**CITY OF ALBUQUERQUE
PLANNING DEPARTMENT
March 5, 2014
DRB Comments**

PROJECT # 1004530

APPLICATION # 14-70054

RE: Las Miradas Townhomes

SITE PLAN FOR BUILDING PERMIT

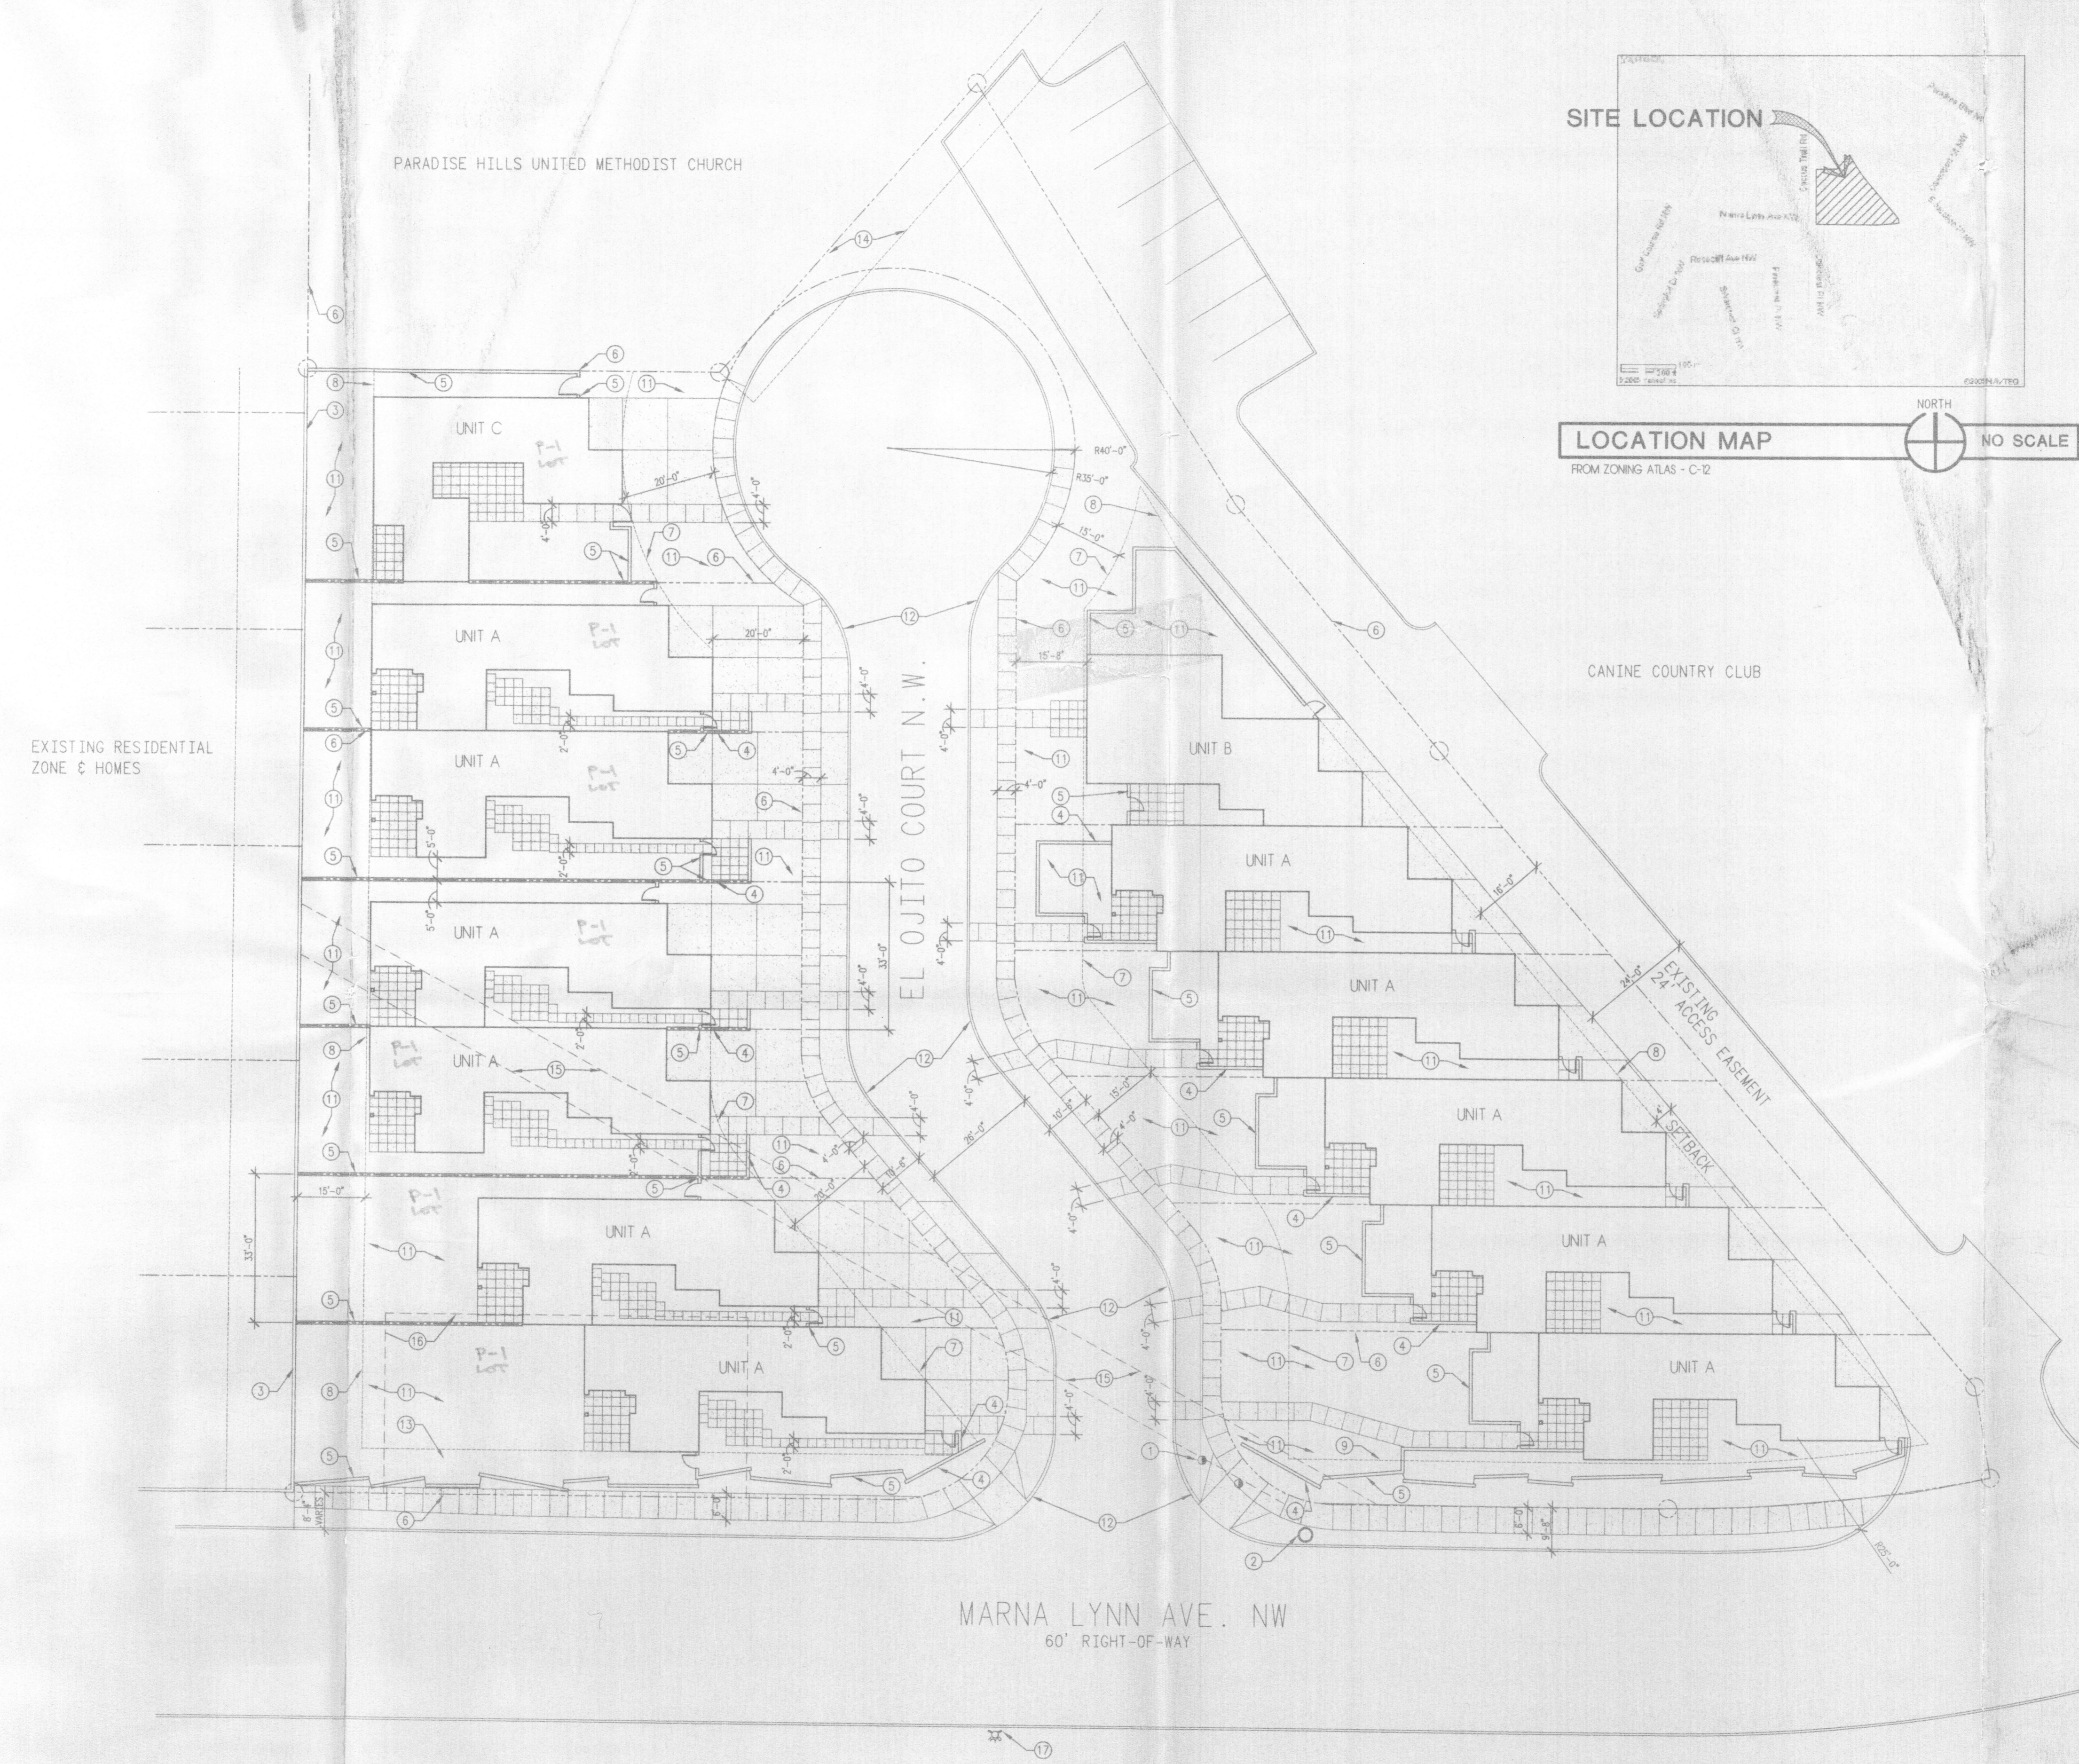
It appears that sidewalks along the east side of El Ojito Ct could be constructed now since access to the 3 undeveloped lots on this side of the streets will be from the easement in the back of the lots.
